From: Josh Stubbs [REDACTED]
Sent: 17 September 2018 20:43
To: Daun Johnson
Subject: RE: Further Information Required on Your Ref: PP-07186584 Our Ref: Y/69/18/HH

Re: 8 East Bank North End Road Yapton

location plan

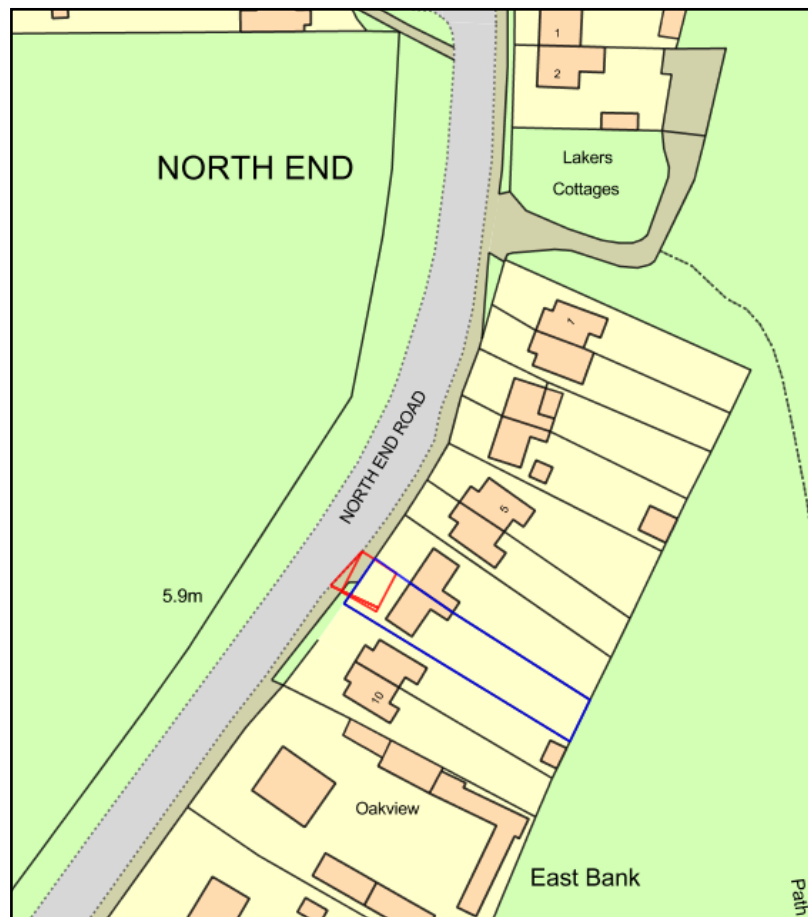
Please see attached our amended block plan. We are unsure if our visibility splays meet your requirements. On the block plan we are unable to follow a 70m line. However having assessed the site, visibility is to the Lakers cottages (approximately 70m) and beyond as can be seen on the location plan. Please inform us if this is unsatisfactory and how we can meet the requirements.

site plan

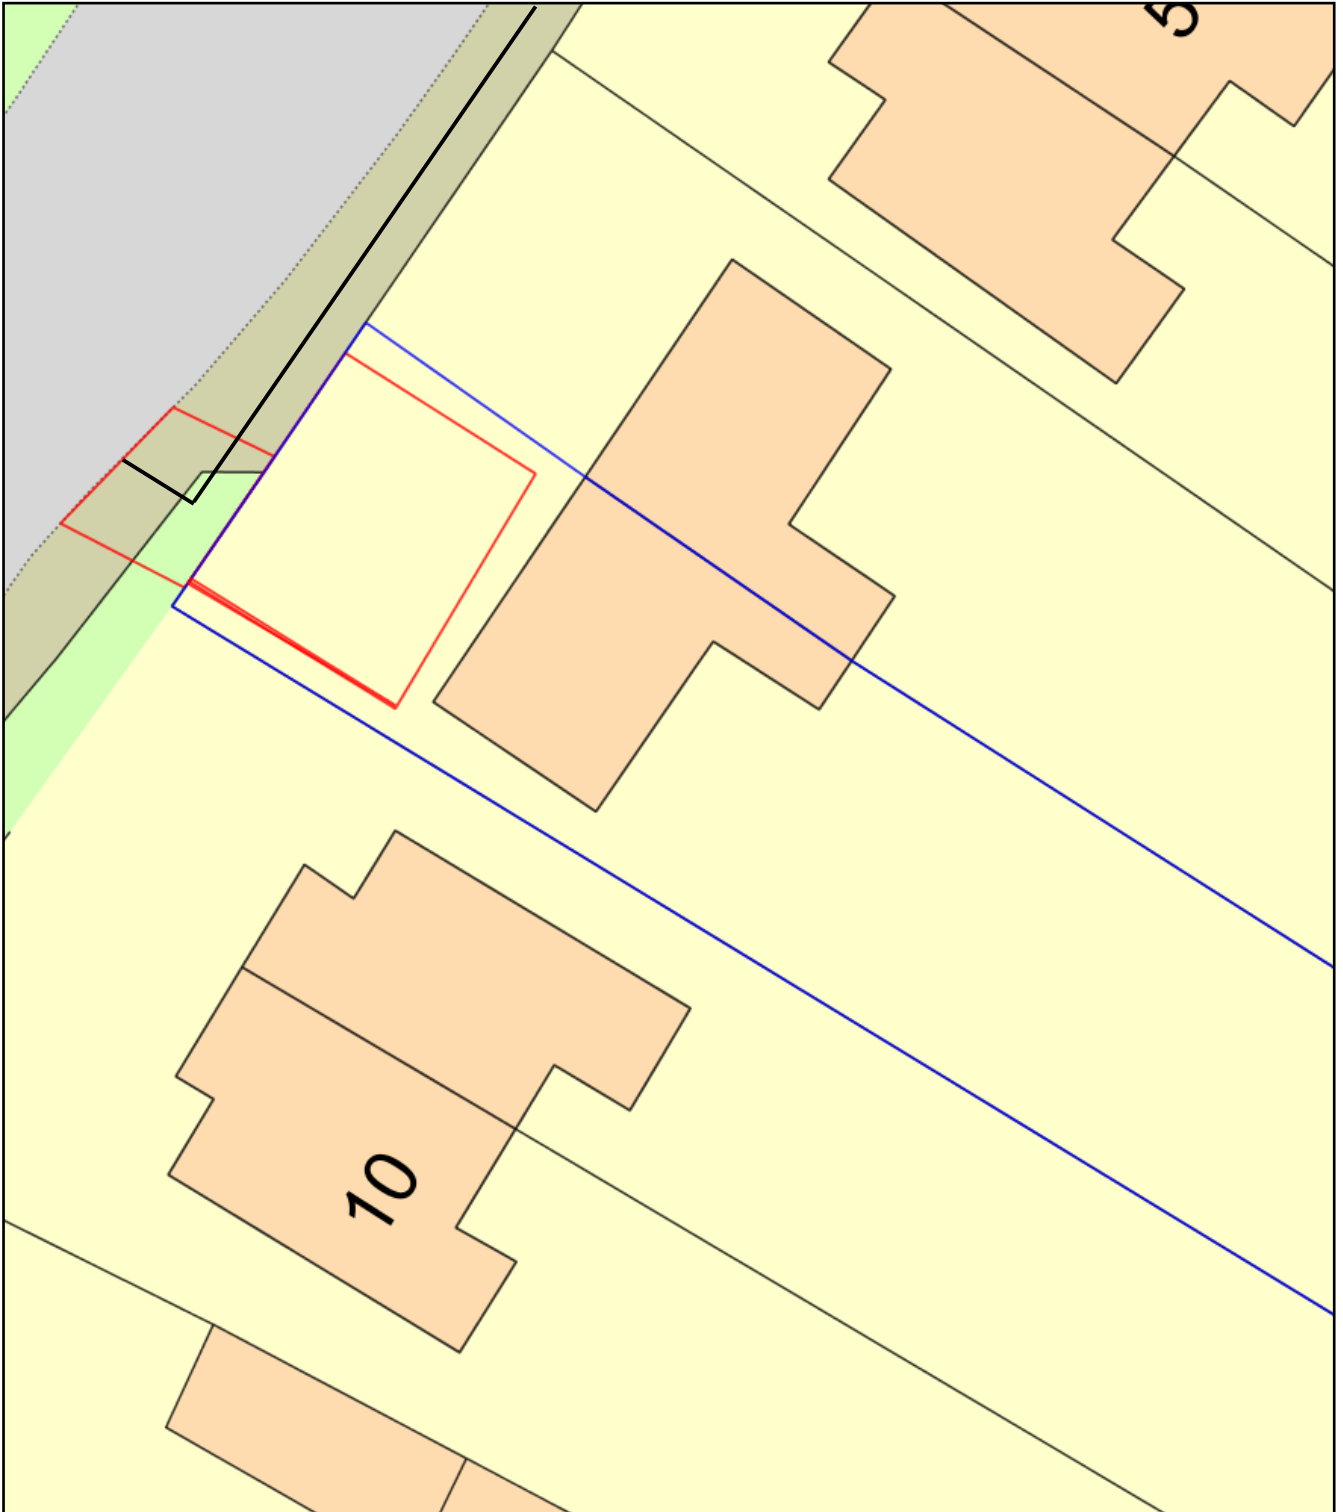
You need to amend the block plan to include visibility splays. A visibility splay is formed by measuring to a point 2.4m back from the carriageway in the centre of the driveway or entrance. A line (70m long in the case of a 30mph limit) is then drawn to the right, to a point where it strikes the near-side edge of the carriageway.

Please ensure the block plan, if sent electronically, is sent as a pdf as jpgs do not scale correctly.
